Report following a request for further information, negotiations or consultation

REF NO:	EP/179/18/PL
LOCATION:	Gladwyn The Street East Preston
PROPOSAL:	Demolition of existing house & erection of 3 x 3 bedroom houses together with landscaping, car parking and fencing.

Project: Proposed new homes; Gladwyn, The Street, East Preston BN16 1HT			
Drawing: Block plan, bin store elevations			
For: Mrs. J. Simmonds & Mr. P. Beamish			
Drawn: PKS		Date: November 2018	
Scales: 1:50 1:200		No: 2386/01/03/C	
To scale when printed on A3

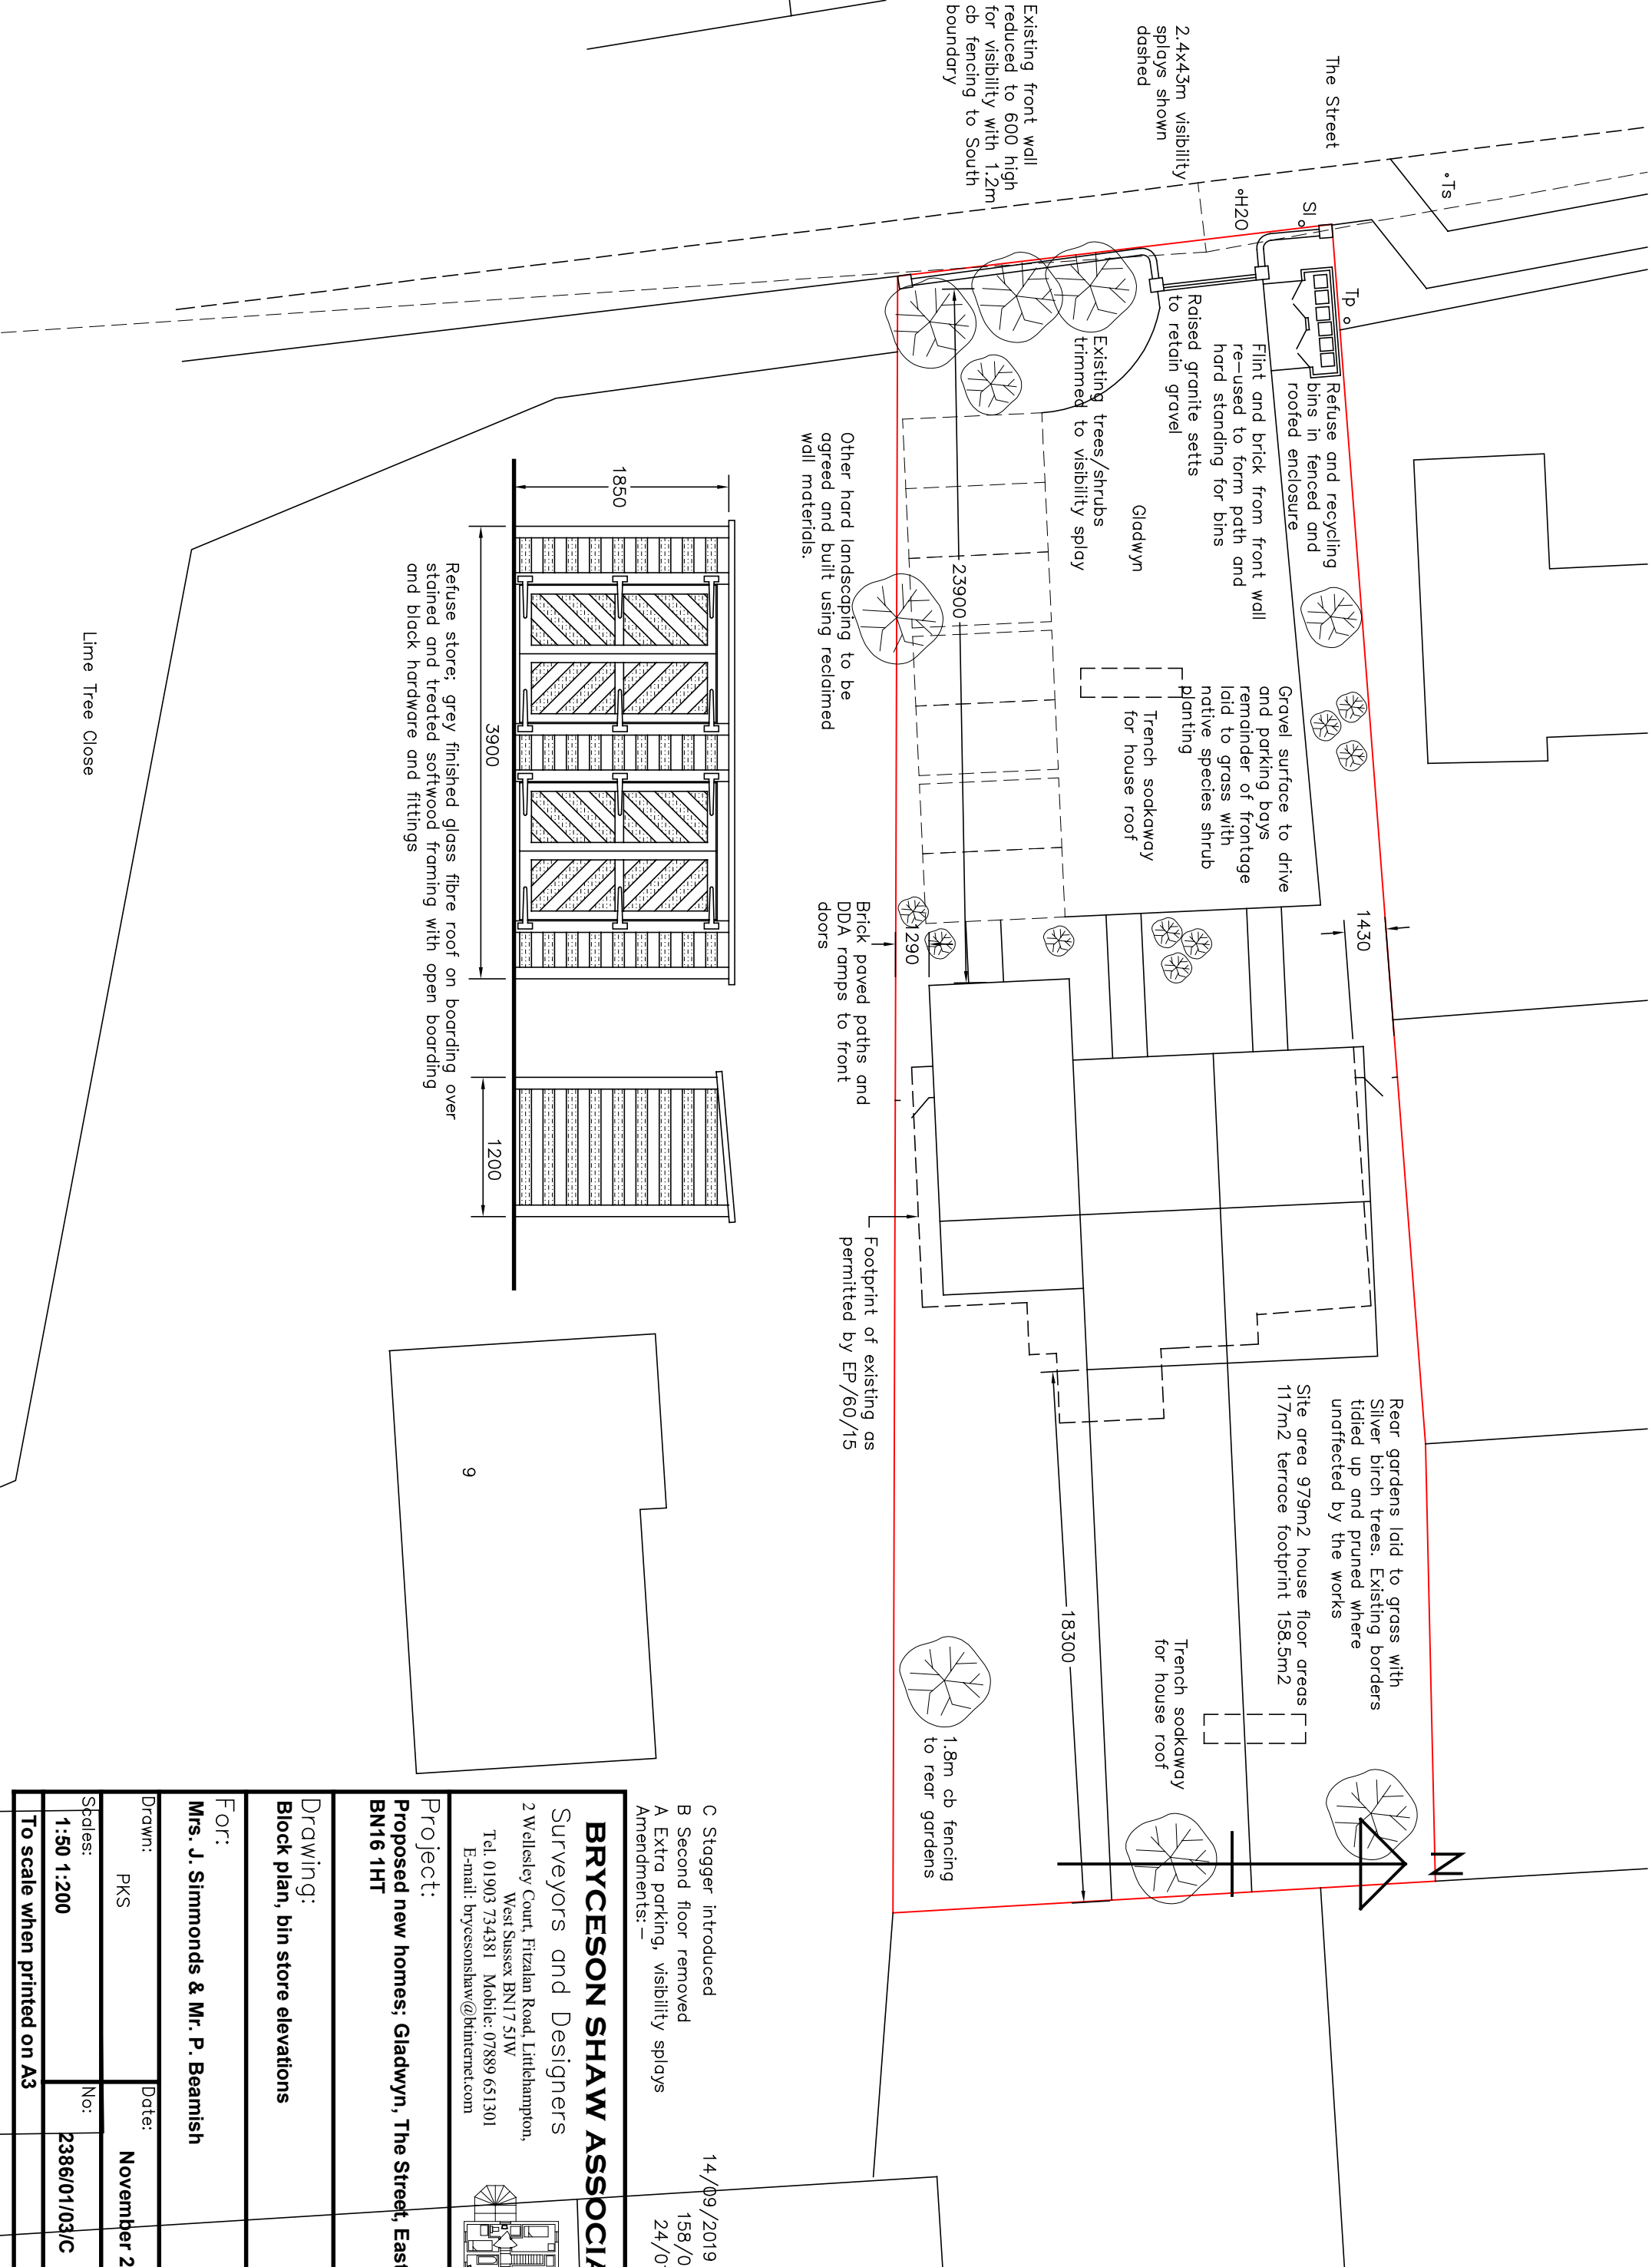
The agent proceeded, after committee, to submit a revised plan to show that with the 3 properties realigned a total of 9, allocated, parking spaces can be provided.

Highway visibility was also discussed and assessed. Visibility to the north is sufficient and no works to the wall would be required in this direction. Current visibility to the south is substandard and the minimum 43m cannot be achieved due to the position and height of the wall. Current visibility in this direction is estimated to be approximately 12m.

Highway officers would not support the proposal if the existing height and position of the wall was retained as it obstructs visibility in a southern direction and the proposal would intensify the use of a substandard access.

However, the revised plan also shows the wall to be demolished and reconstructed set back into the site by 500cm. The wall is proposed to be rebuilt to the same height using the recovered flint; a condition, number 10, is proposed that before the occupation of the dwellings takes place details to reconstruct the wall are submitted and agreed with the Council.

Highway officers confirmed that with a relocated wall, as proposed, the required 43m visibility splay to the south can be achieved and that the southern brick pier can remain in place as it does not impact upon the visibility splay.
